20th January 2025

Planning reference: 3/2024/0996

Location : 98 Ribchester Road and land adjacent 94 Ribchester Road, Clayton-Le-Dale, BB1 9HQ

Proposal : Approval of details reserved by conditions 9 (SW drainage), 12 (drainage scheme)

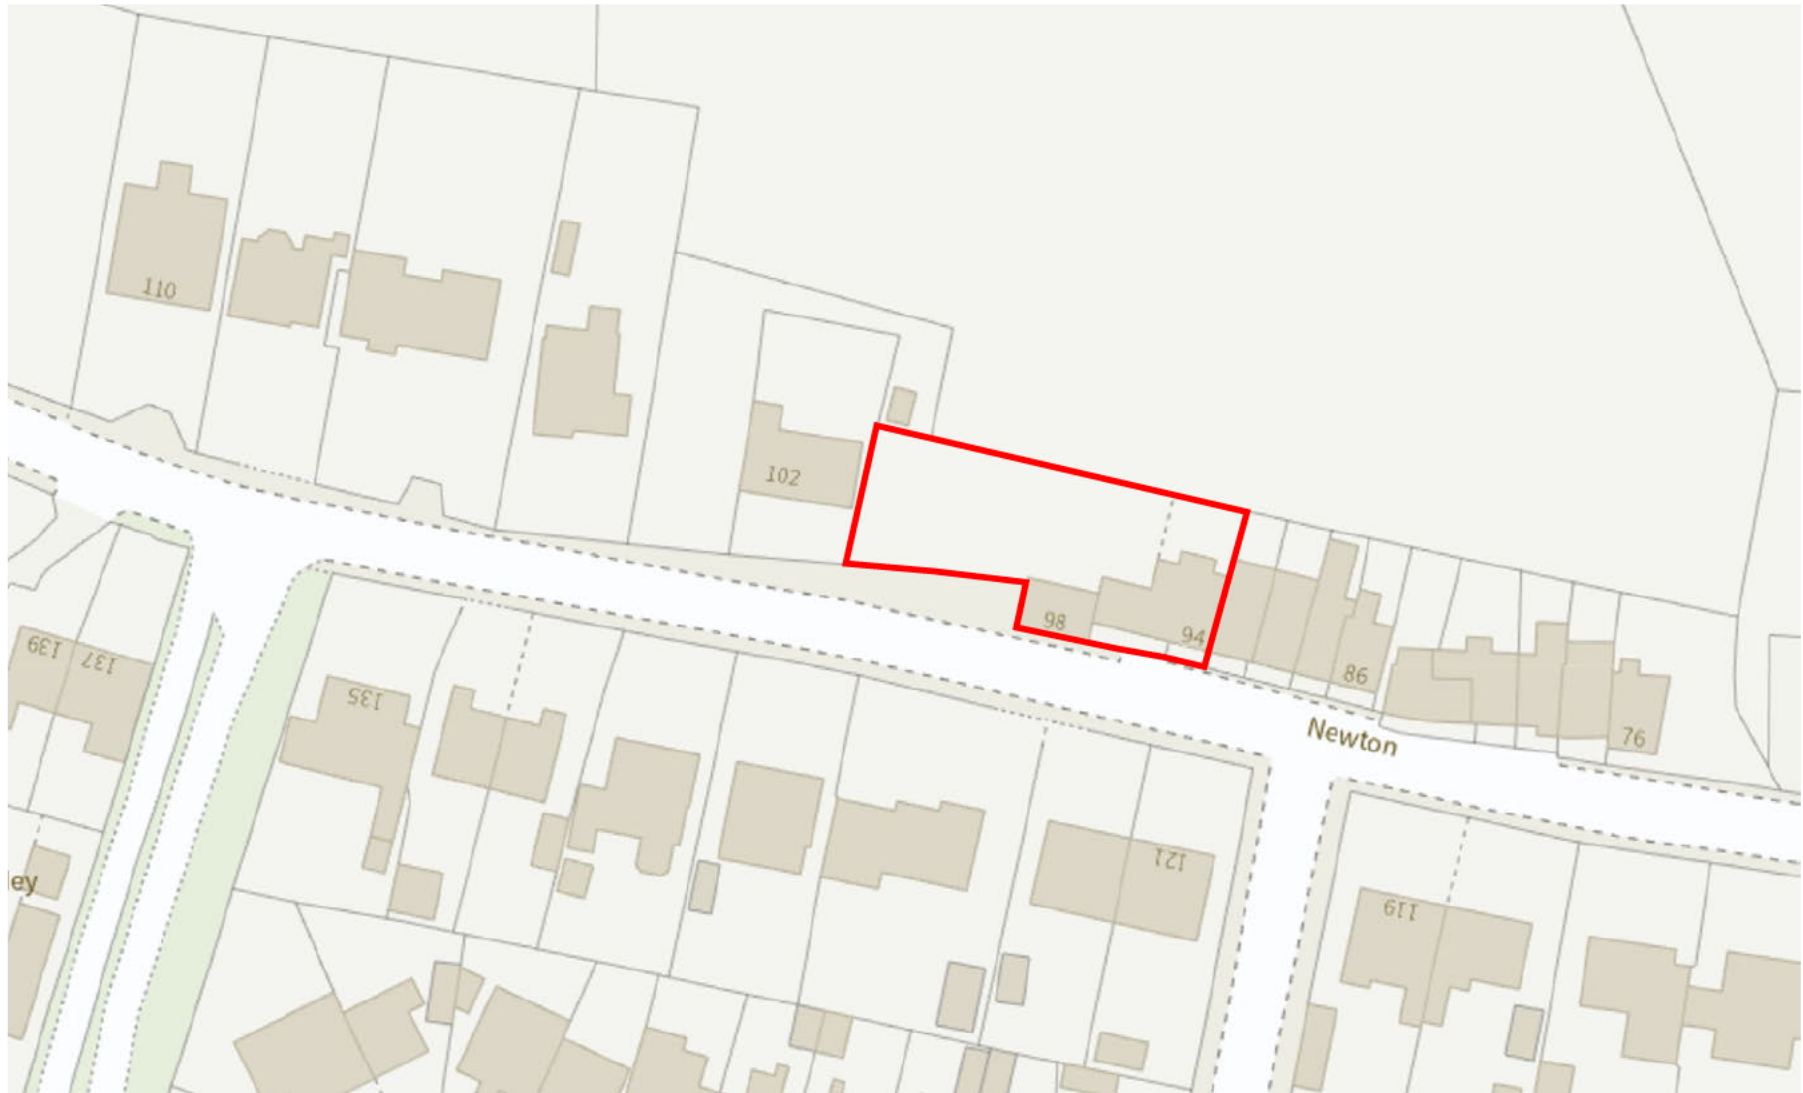
- It is unclear how the connection is being made with the public wastewater network.
- The sewer shown on our records is being assumed to be a combined sewer. It is shown as a foul only sewer.

Foul water from the proposed dwelling will discharge into the existing site drainage system that will continue to serve no. 94 Ribchester Road and into the 225mm diameter public sewer that lies within Ribchester Road via the existing connection.

Surface water from the roof of the proposed dwelling will be restricted to 2.0 l/s with attenuation storage provided within the site and discharged into an existing manhole on the internal site combined drainage system that lies within the site boundary.
